RE: PLANNING REF: 190/18/PL.

ST. MARY'S CLOSE, HURST ROAD, RUSTINGTON. BN16 3AP

REFERENCE R/190/18/PL

Drawing Title:
ADDITIONAL DWELLINGS
BLOCK/ SITE PLAN

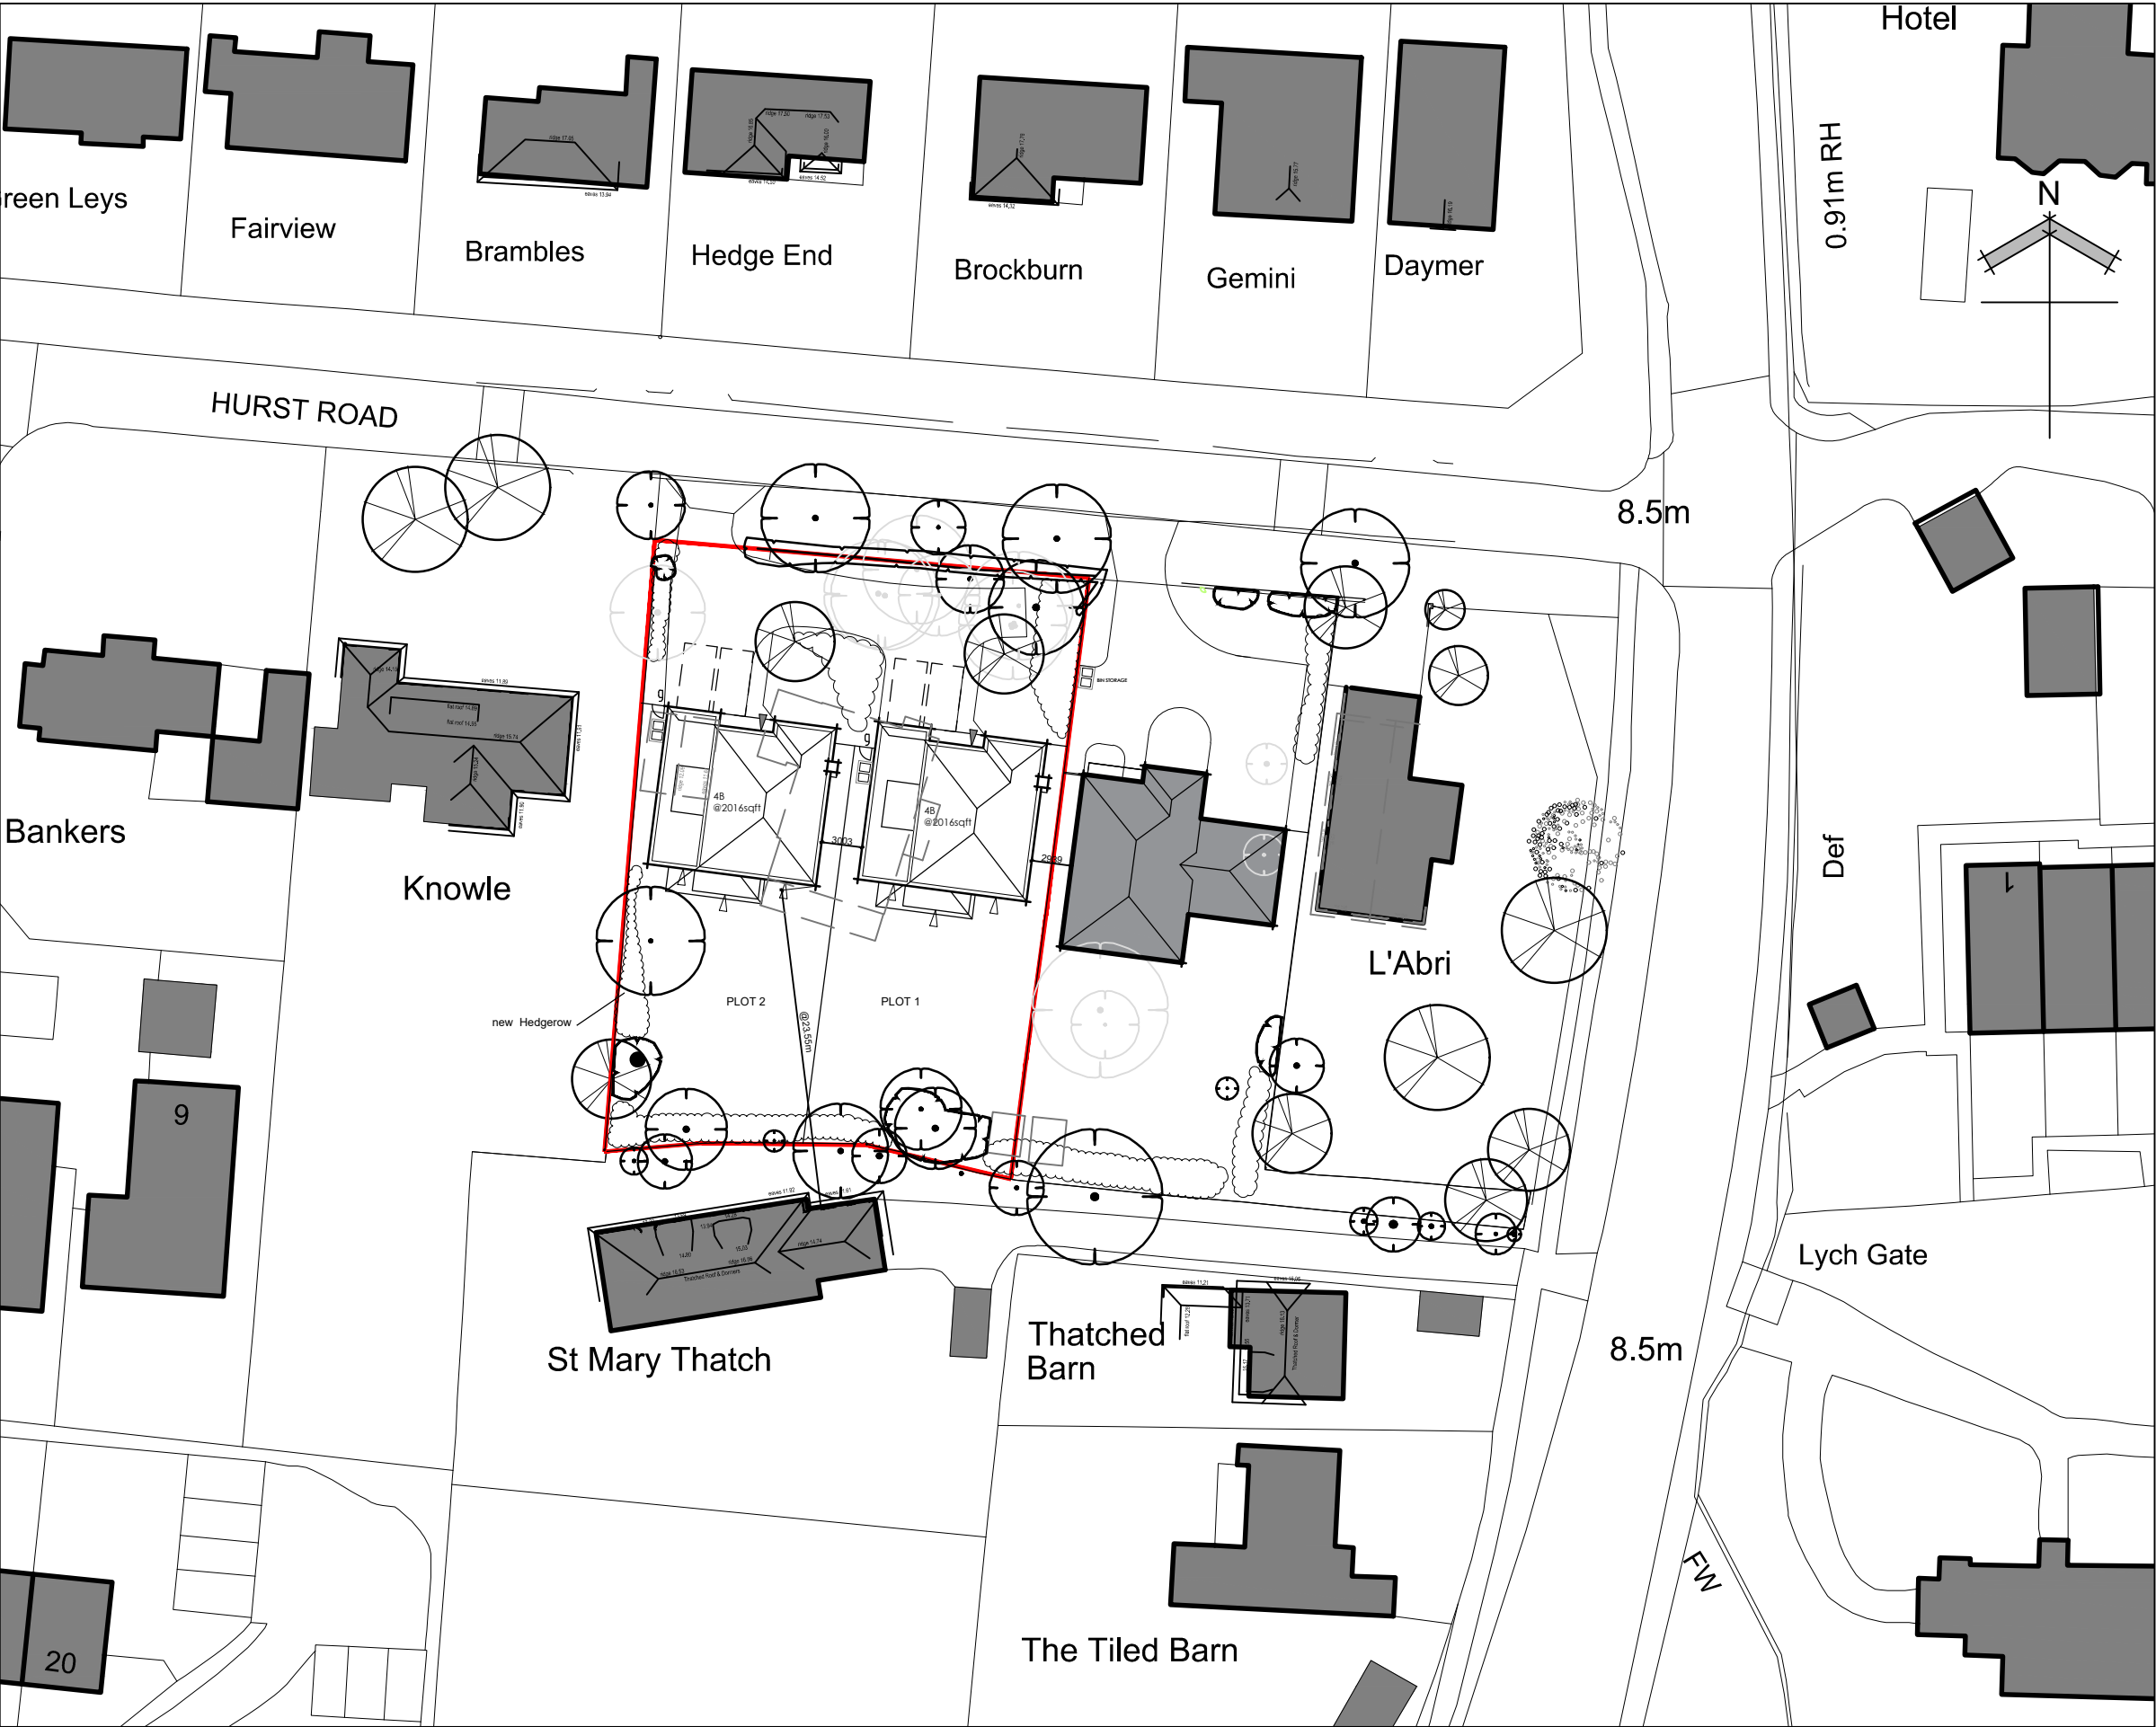
The Appeal Decision (Para 5) stated "Hurst Road is characterized by a mixture of houses bungalows/chalet bungalows of varied designs that occupy quite spacious plots". This revised application clearly conflicts with this official observation/assessment and our acceptance of the compromise proposal of 2 new houses is accordingly conditional on the 2 new houses being of distinctively different design and orientation. Yours faithfully

Drawing Title:
ADDITIONAL DWELLING
PLOTS 1 & 2
ELEVATIONS

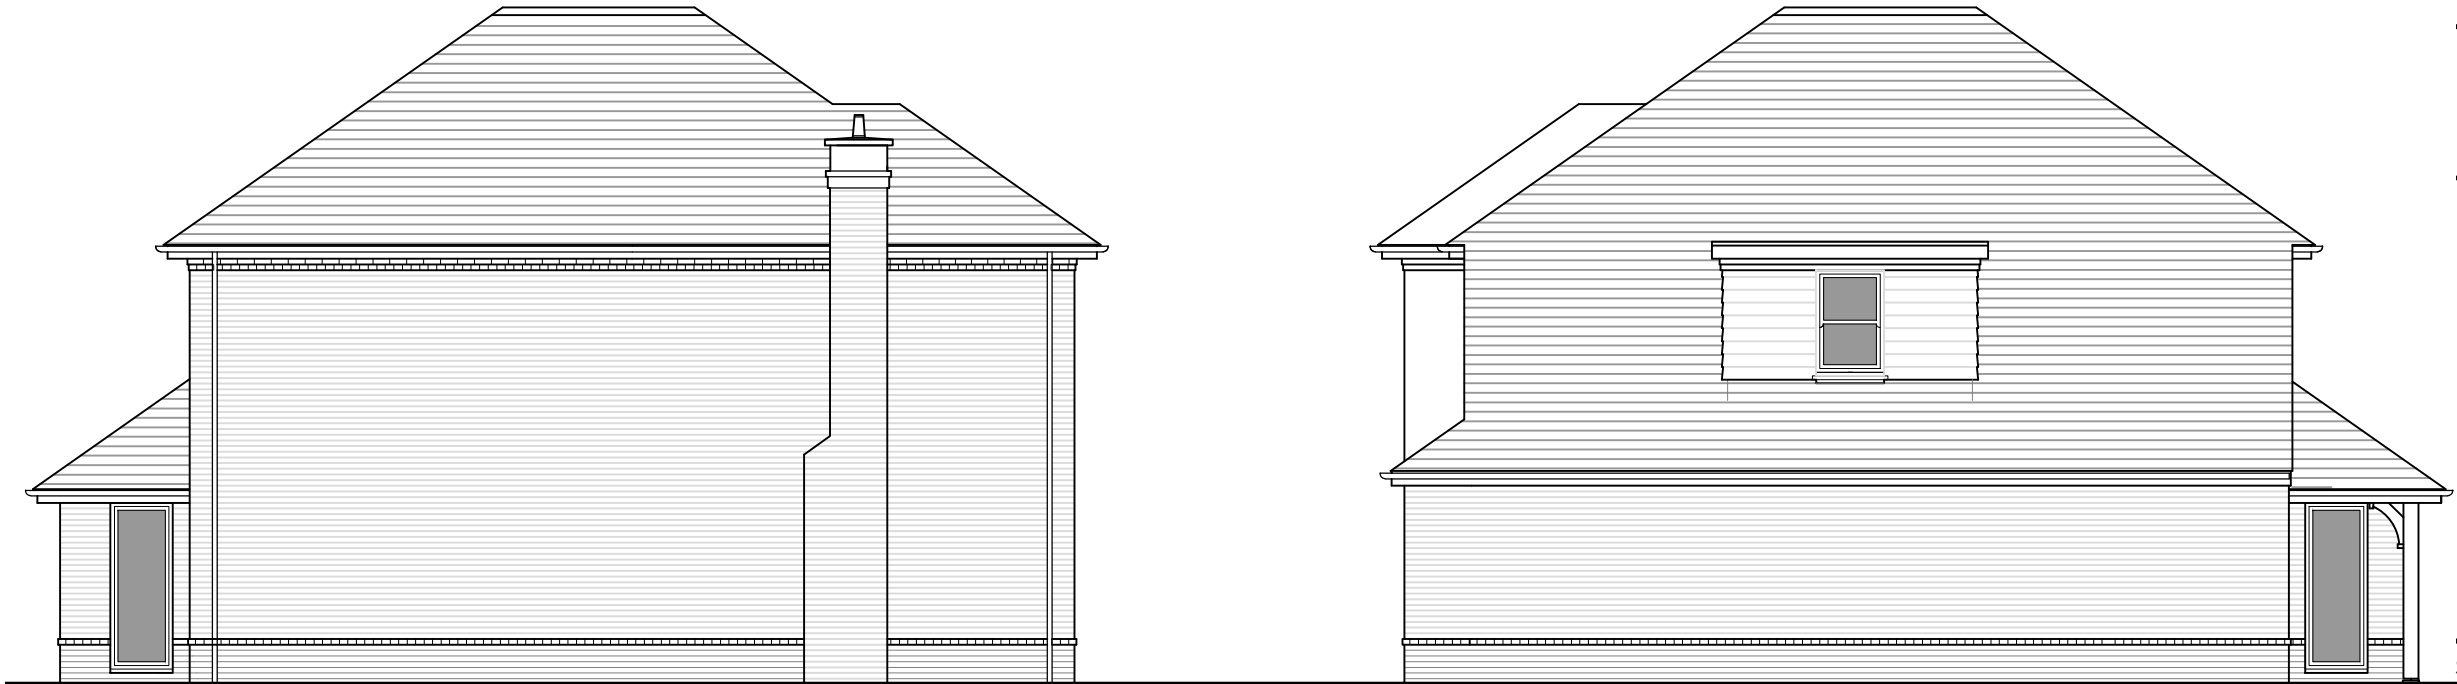
The revised planning application to build 2 identical houses does not directly conflict with paras 5 and 6 of the Secretary of State's Appeal Decision APP/E3810/W/17/3182585 and we are therefore reconciled to the erection of 2 new houses.
